City of Albuquerque

RE: GOOLDEN PRIDE BBQ, CHICKEN, & RIBS (K20-D20A), GRADING AND DRAINAGE PLAN FOR GRADING AND PAVING PERMIT APPROVALS. ENGINEER'S STAMP DATED DECEMBER 13, 2000.

- **Case No:** K20-D020A
- **Submittal dated:** December 15, 2000 by Levi Valdez
- **Project Title:** Golden Pride Chicken
- **Location:** Central and Parsifal
- **Approval Type:** Grading/Paving Permit
- **Note:** *This submittal concerns the construction of a new asphalt parking facility behind the existing Golden Pride Chicken. The site is intended to drain east to Parsifal and south through the existing parking area to Central.*

A PROPOSED GRADING AND PAVING PLAN
FOR
GOLDEN PRIDE BBQ, CHICKEN & RIBS
(10015 CENTRAL AVENUE, N.E.)
ALBUQUERQUE, NEW MEXICO
DECEMBER, 2000

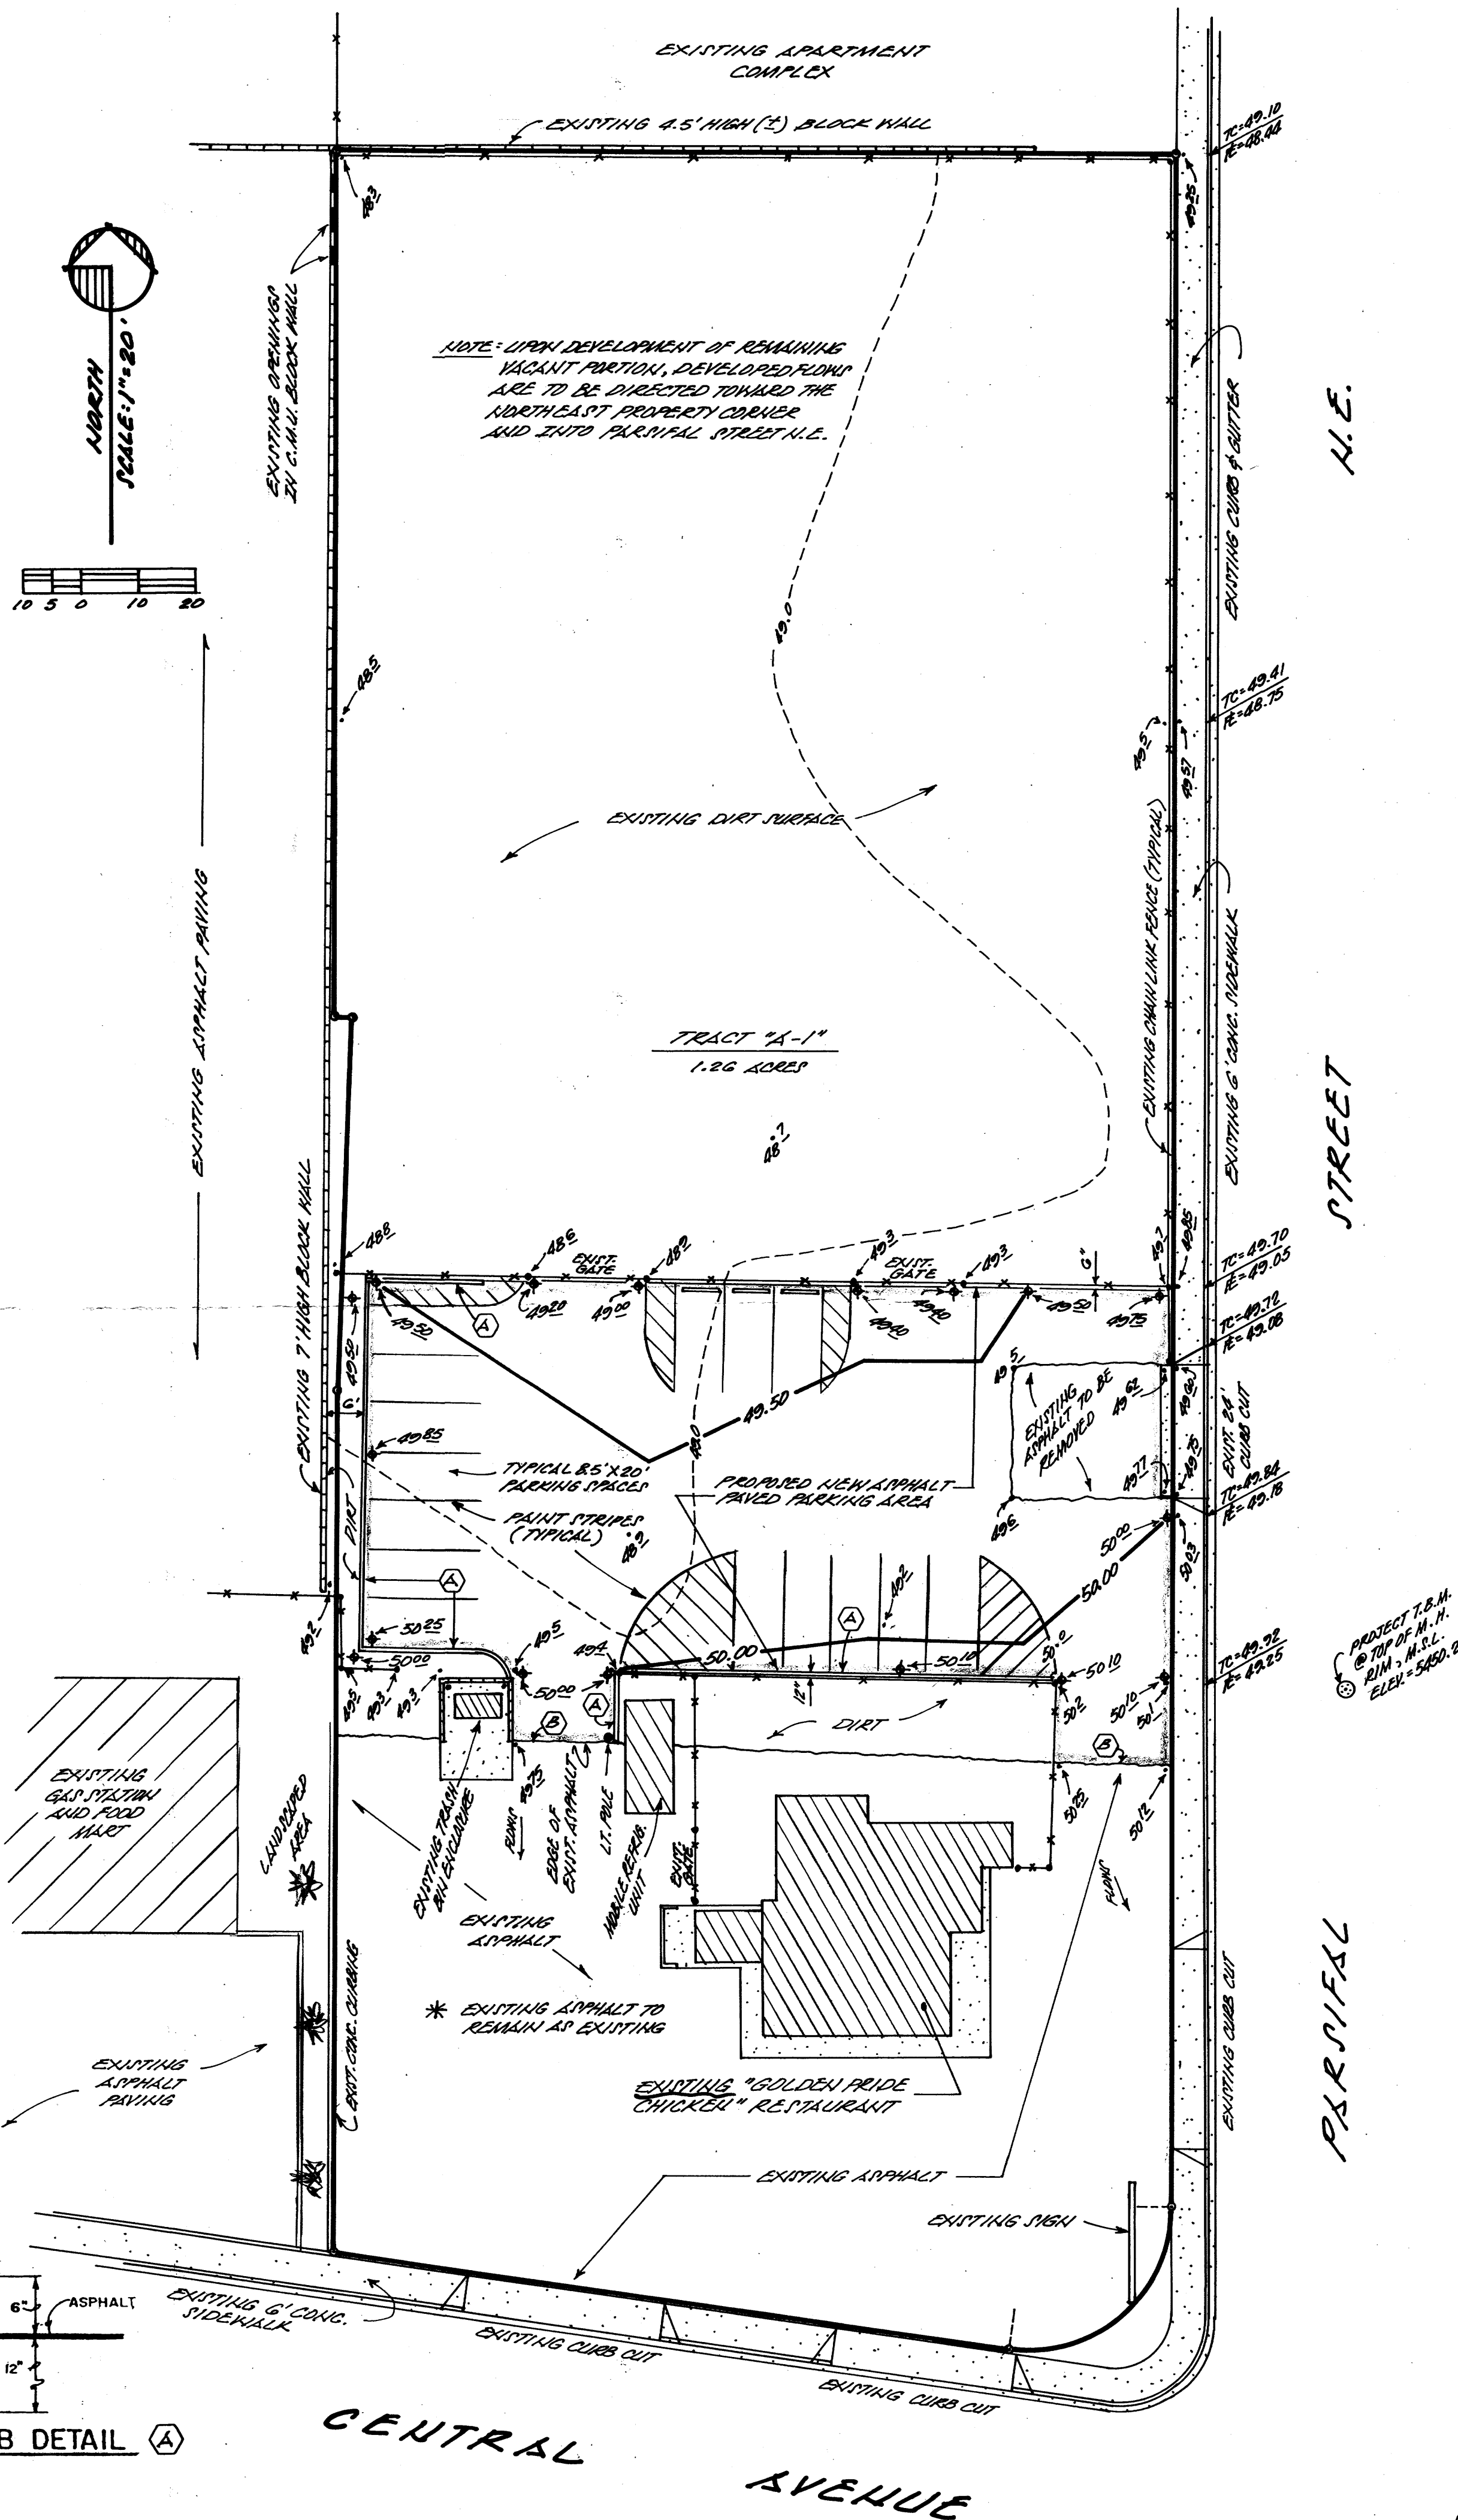
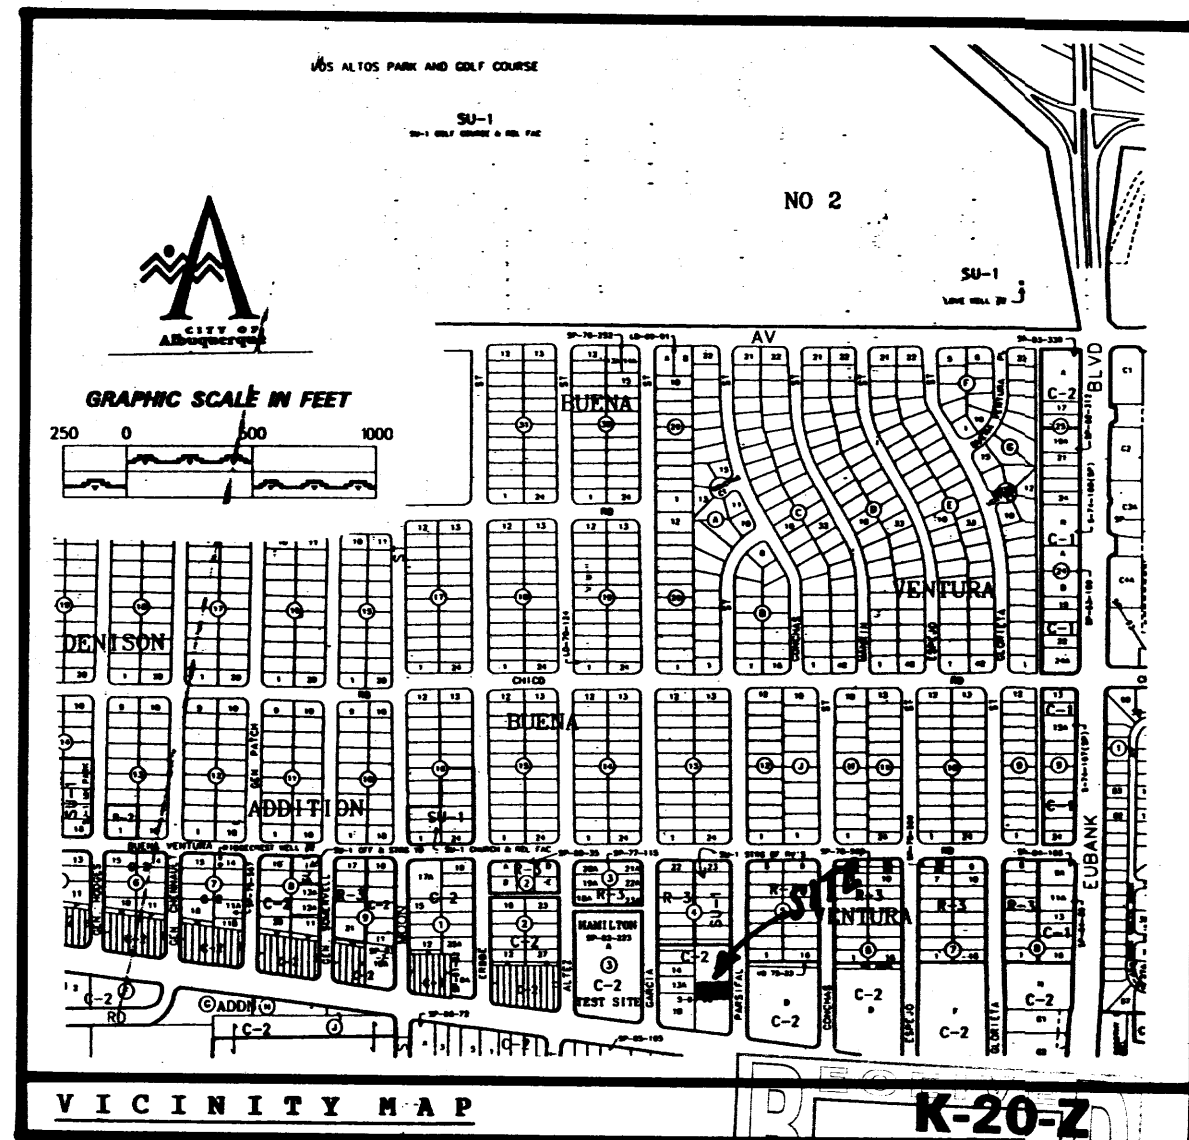
Greater topographic definition is needed.

The finish floor elevation of the existing building and existing spot elevations should be given.

Offsite topography is needed to indicate if there is any effect from flows originating thereon.

Only one existing contour is shown. Without spot elevations and other contours, drainage patterns are undefined, i.e., subbasins.

Indicate capacity of existing concrete ditch and identify any associated easements.

Based on the submittal stamped December 13, 2000, the proposed grading and drainage plan concept does not appear to be sufficient and should not be approved for grading permit at this time.

- ✓ • No offsite topography is shown on the plan. It would be helpful in assessing the offsite impact to the subject property.
- Only one contour "49.0" is shown on the plan. At least two contours are required to assess which way the runoff will go.
- ✓ • A finish floor elevation was not indicated on the plan for the existing building. Also, no spot elevations are shown along the roadways and existing parking areas to assess capacity and/or flow direction.
- ✓ • Proposed runoff for the site indicates that the single basin will discharge to at least two separate locations and that no grading is shown on the northern portion of the site to indicate where the water is intended to go. The site should be broken into more subbasins with each analysis point indicated on the plan with adequate discharge capacity to the streets.
